Subject: RE: Attached letter from Kirklees Council regarding application number 2025/90689 at location Penistone Road/, Rowley Lane, Fenay Bridge, Huddersfield, HD8 0JS

I would like to advise that conditions 25 (retaining walls) and 26 (attenuation system) can not be discharge pending the approval of the necessary details, as stated below;

Detail
SITE SECTIONS - E-E TO F-F

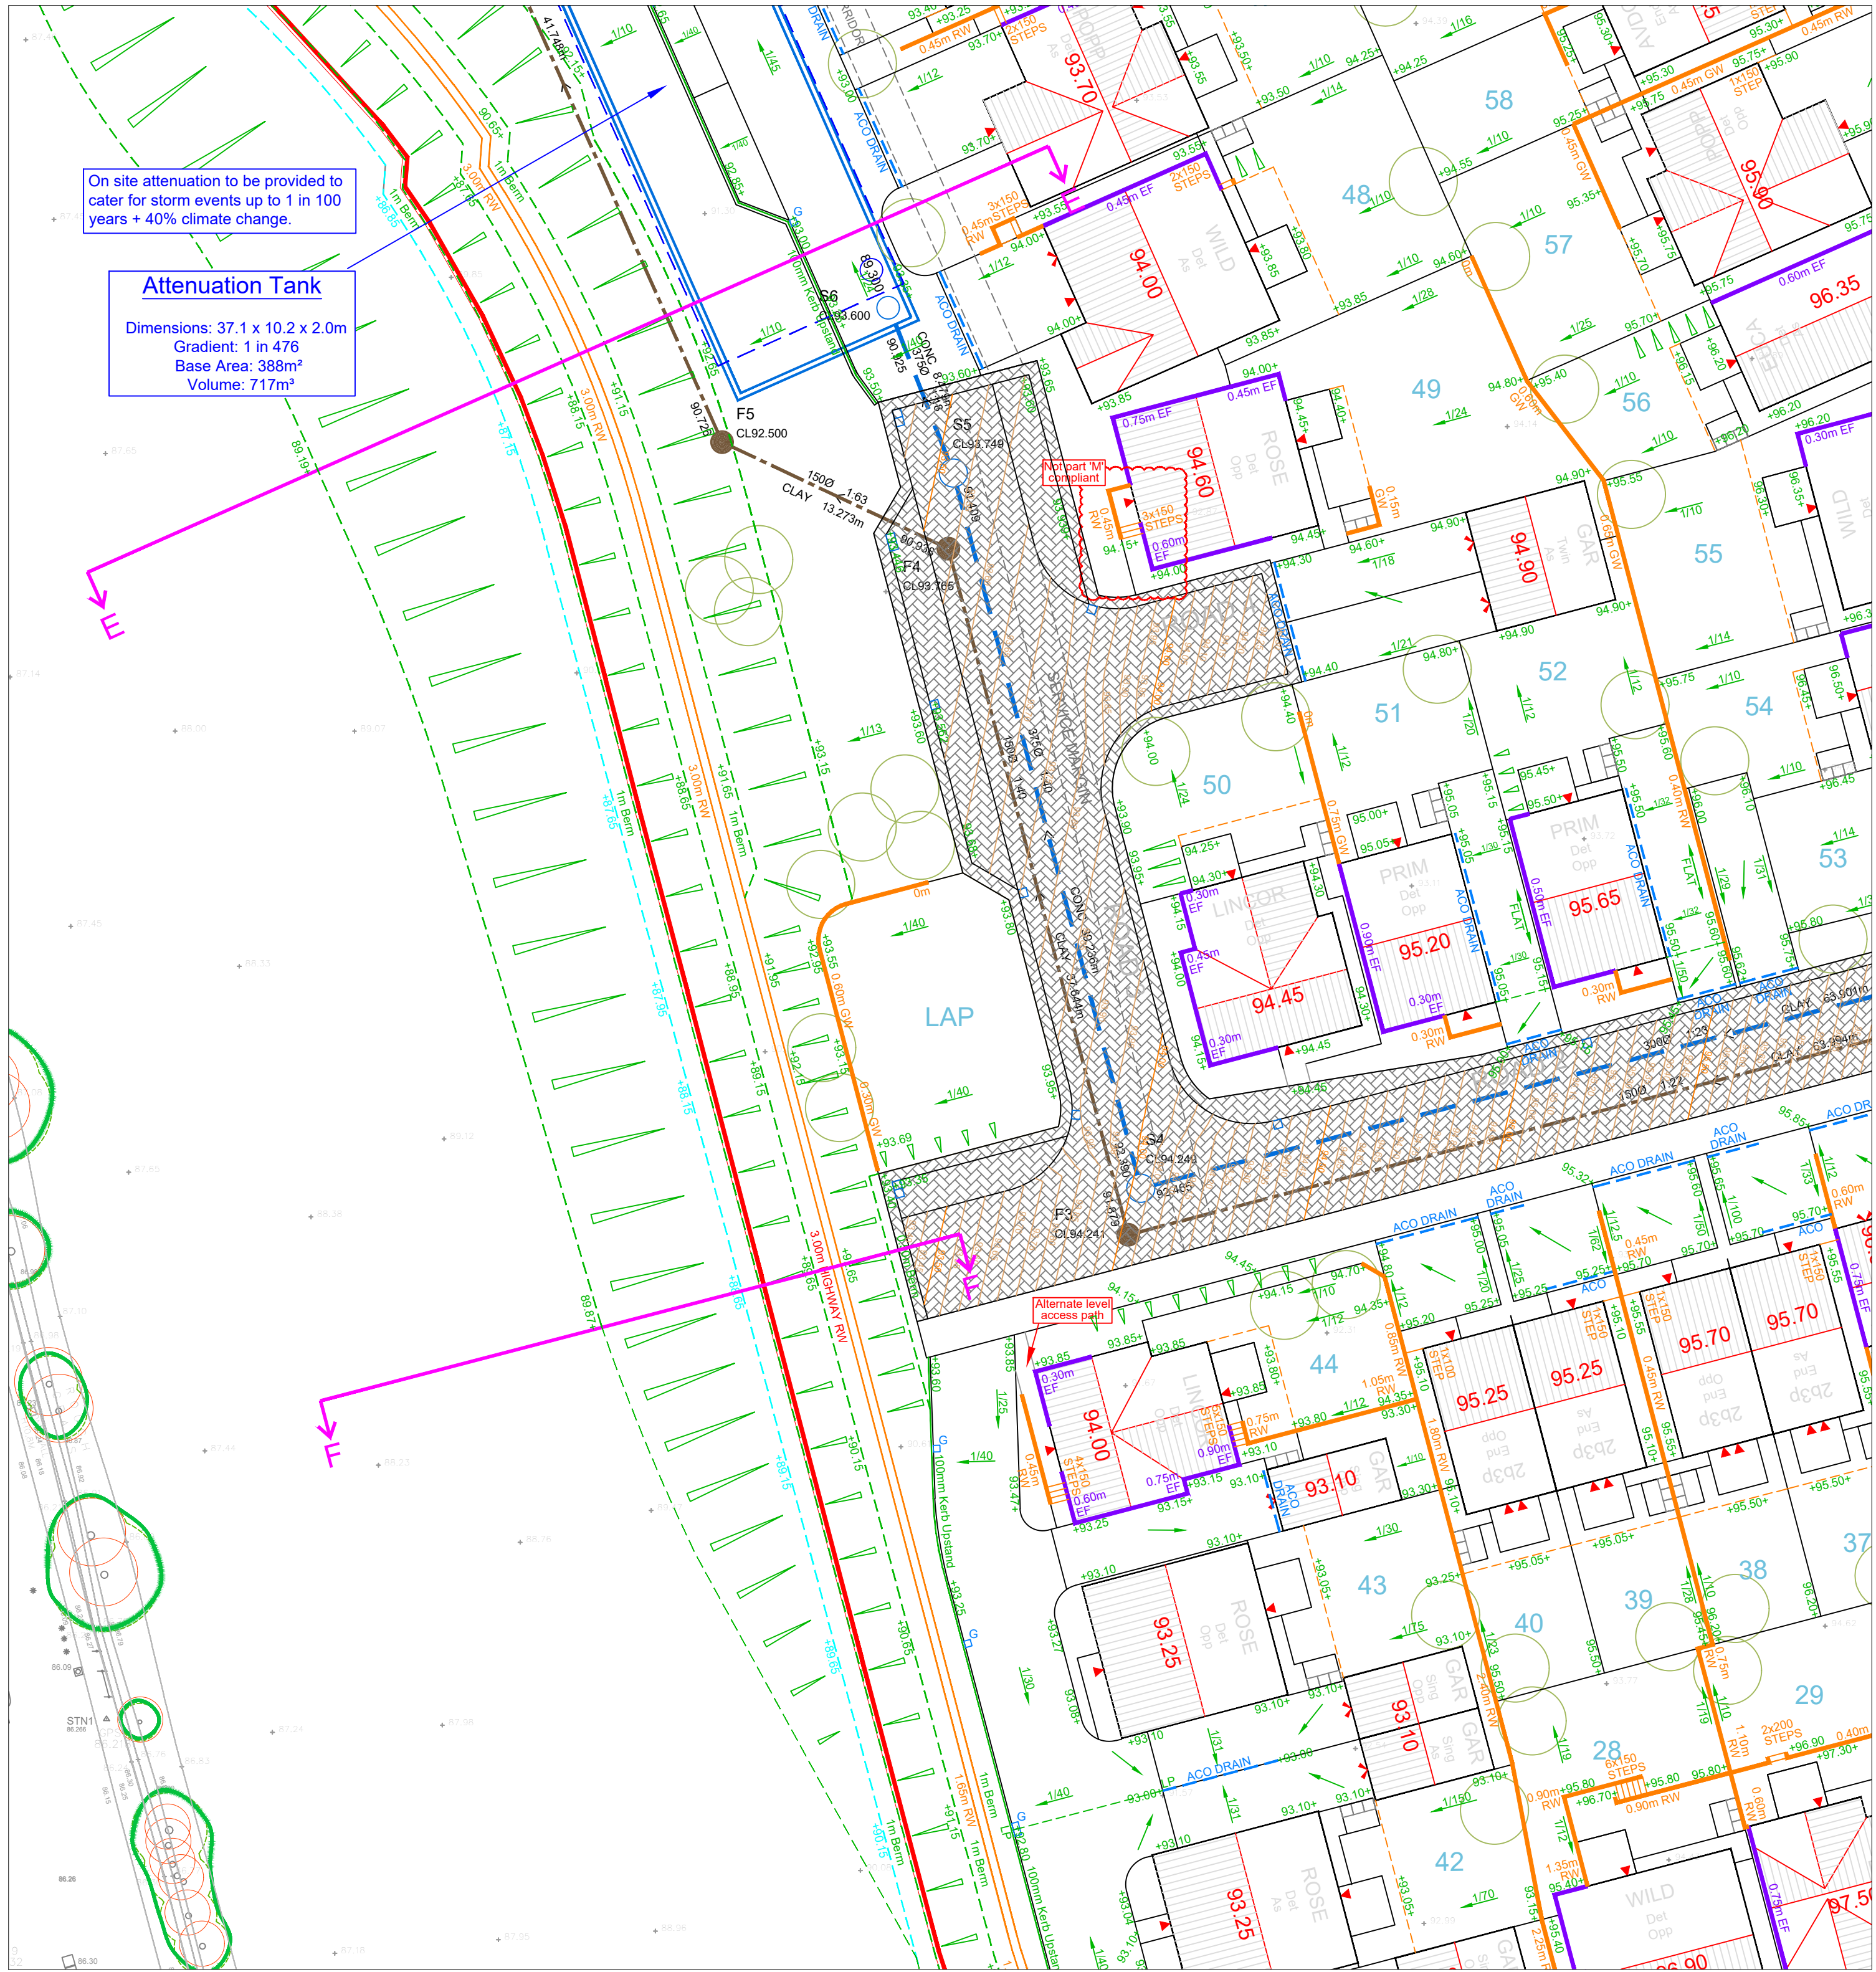
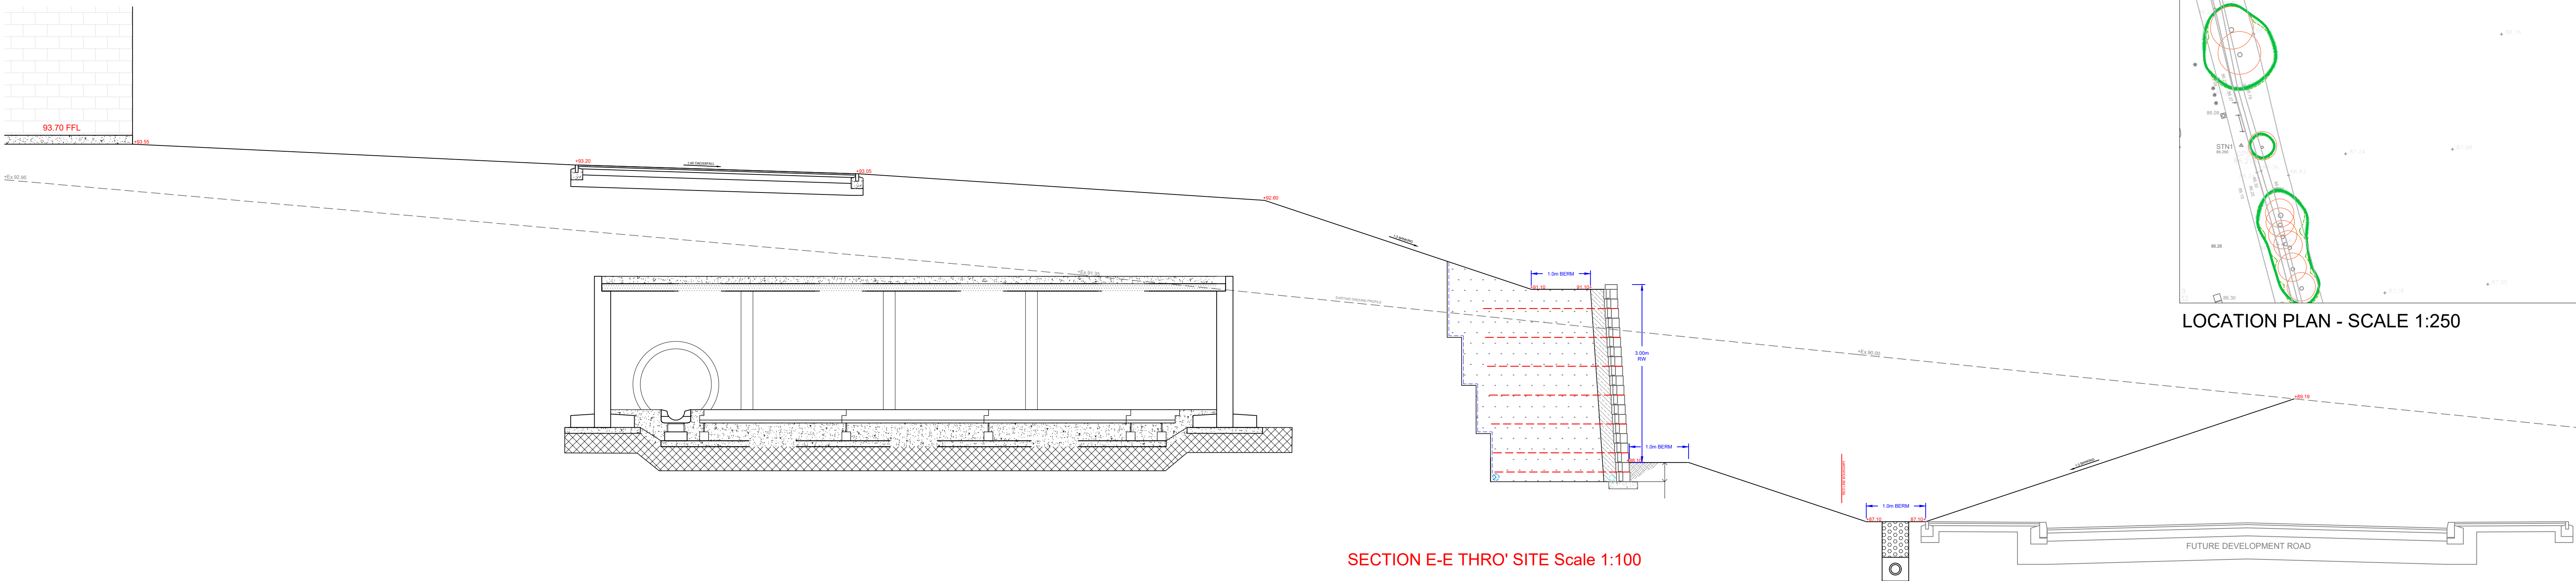
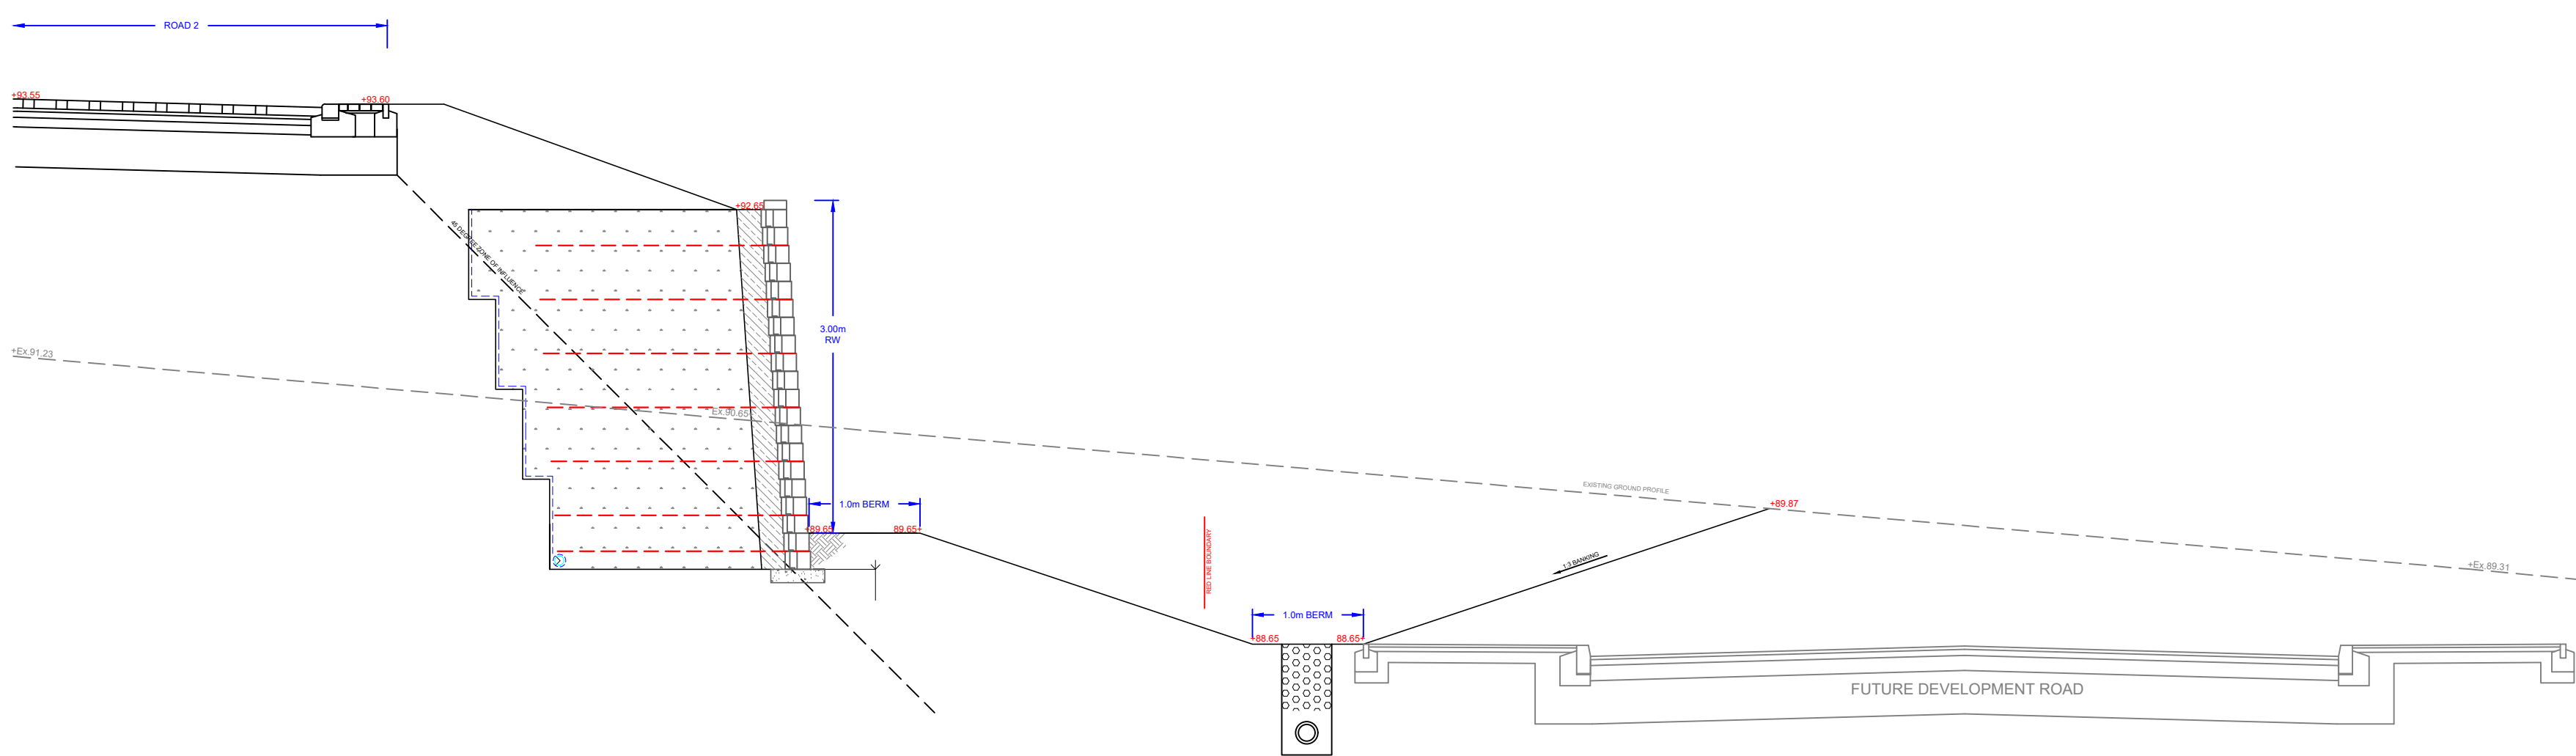
- 1) Submission of suitable of external works drawing for the whole site with appropriate keys for the relevant proposed retaining walls/embankments adjacent to the highway, adoptable highways and the confirmation of location and status of the road labelled “Future Development Road” as well as specifying the lateral dimensions between the proposed structures and adjoining Road on the submitted sectional details to ascertain whether these retaining structures will be liable to a formal technical approval via submission of AIPs.

Detail
MAIN ROAD & SEWER PLAN

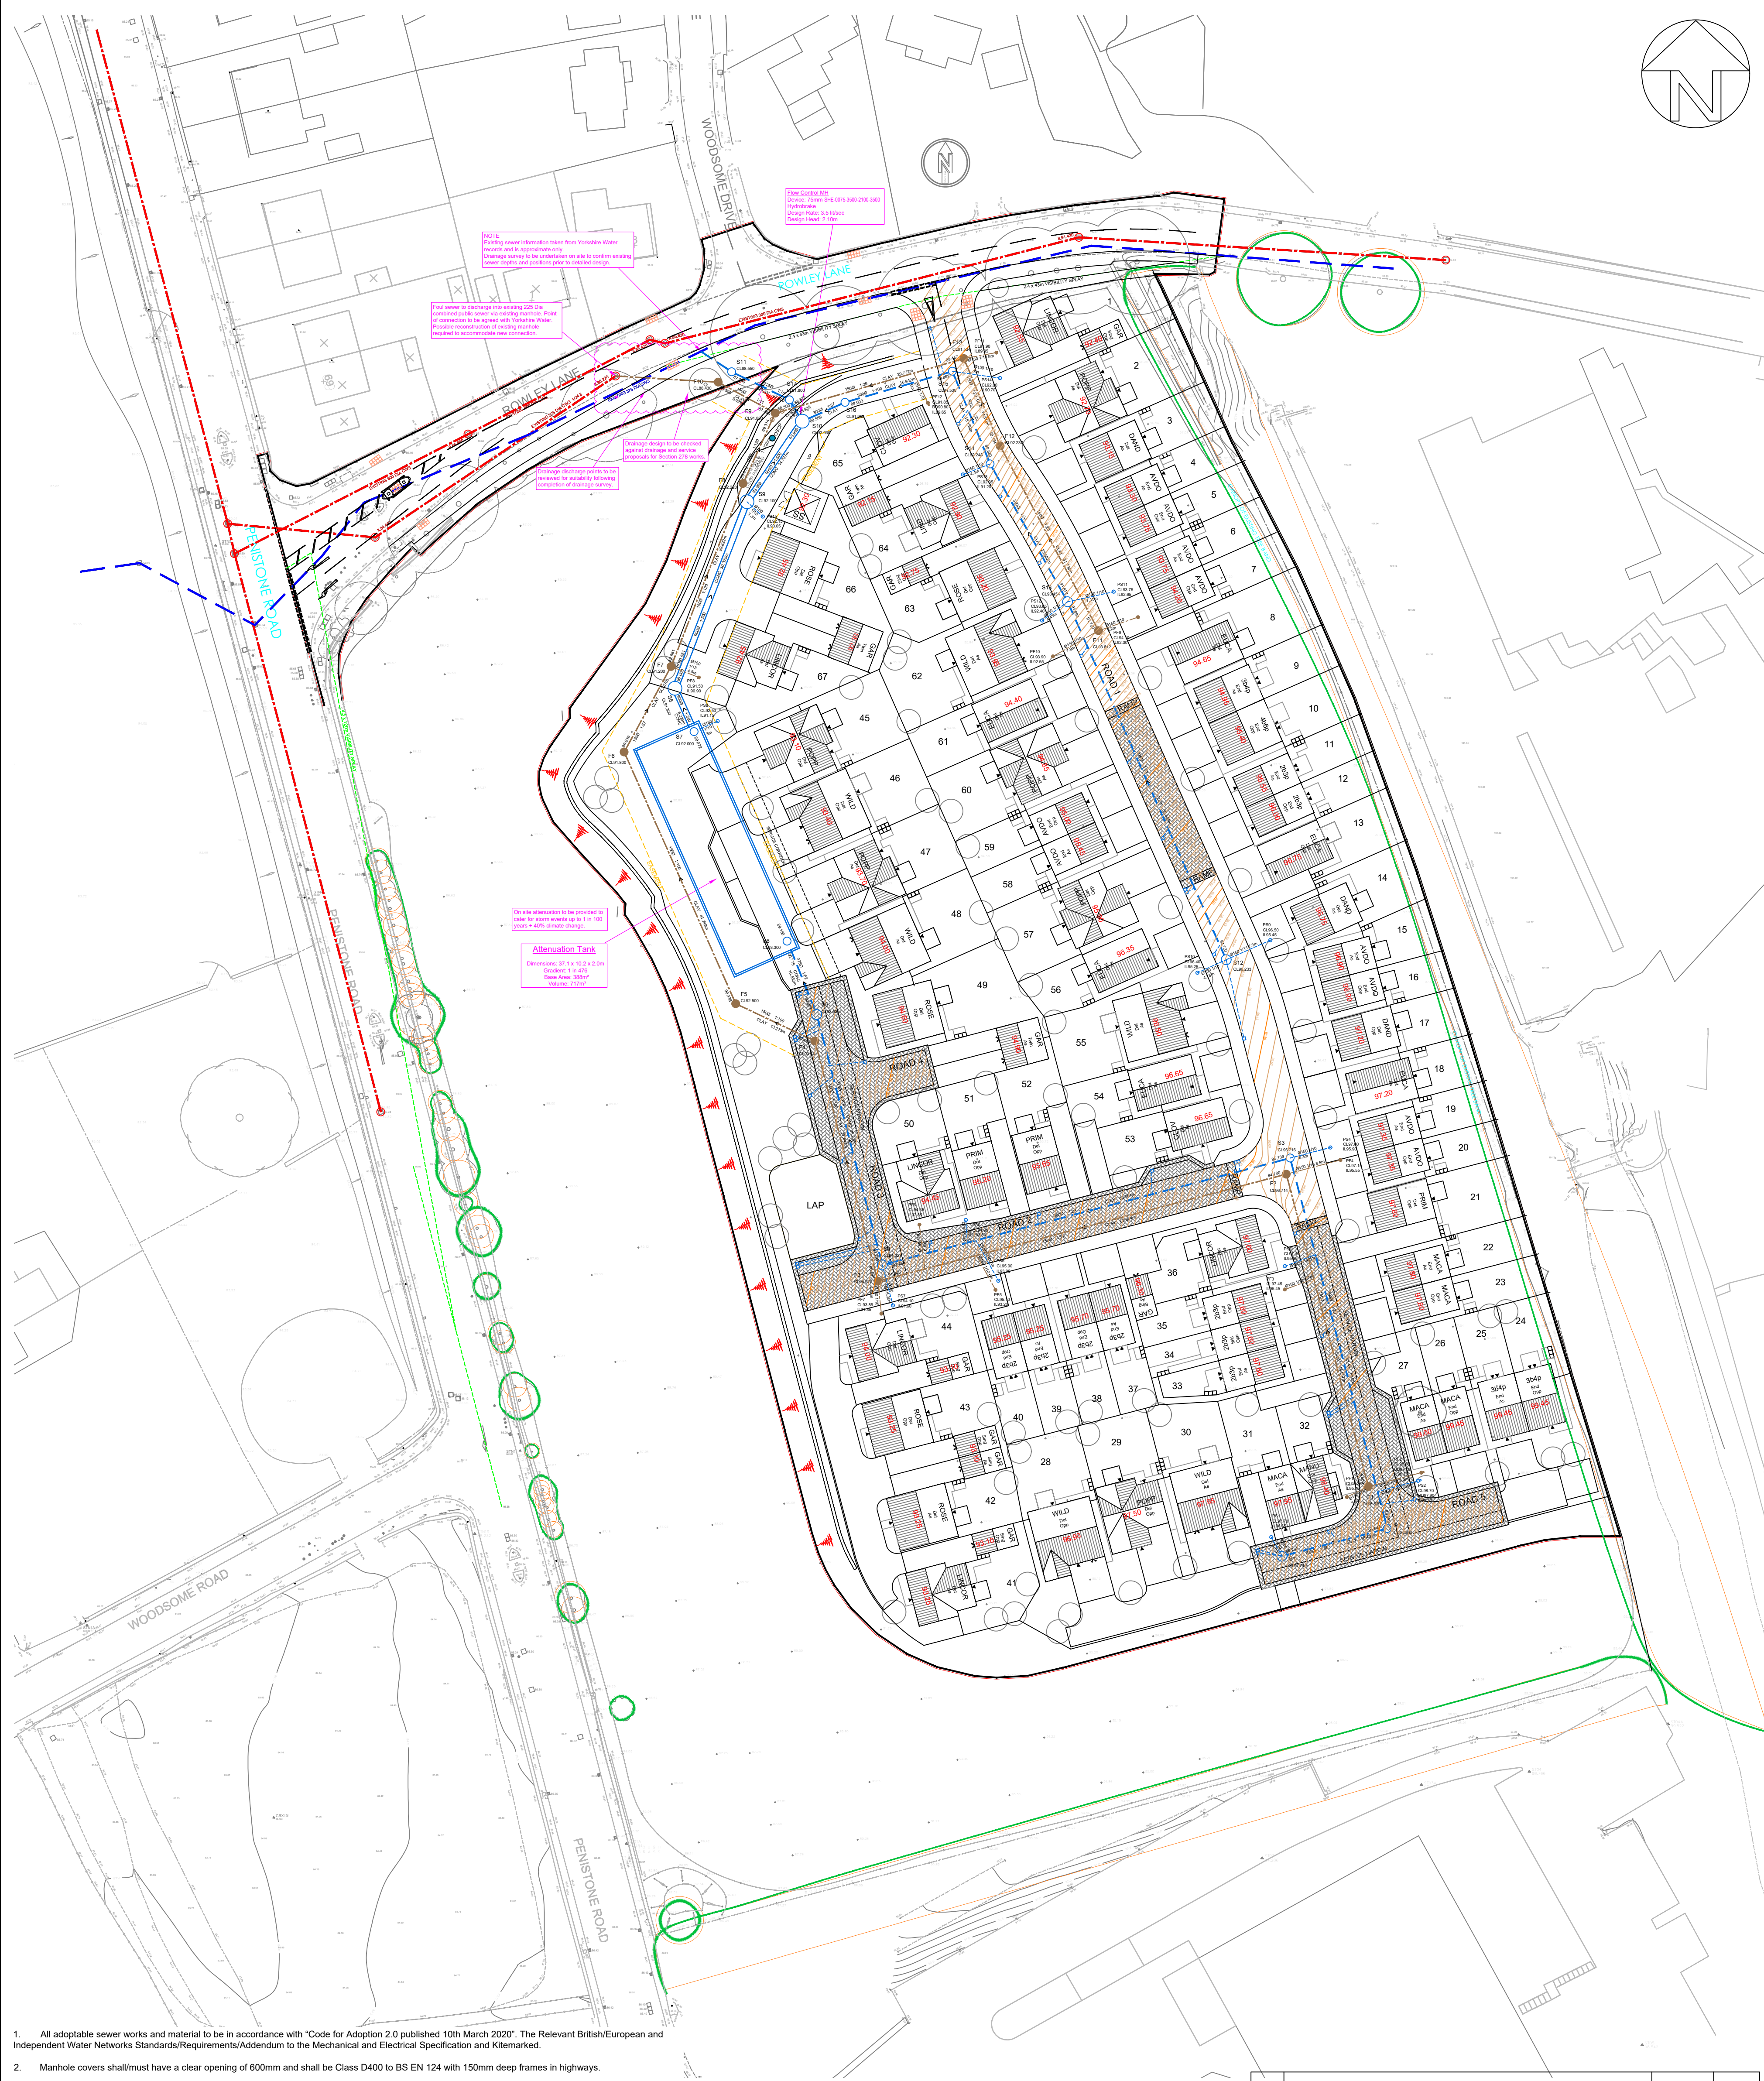
- 3) Provision of a manhole schedule for the surface water attenuation system in order to progress the technical approval process for the oversize manholes at this site. This is subject to the payment of £360.00 increasing to £375.00 from 1st April 2025.
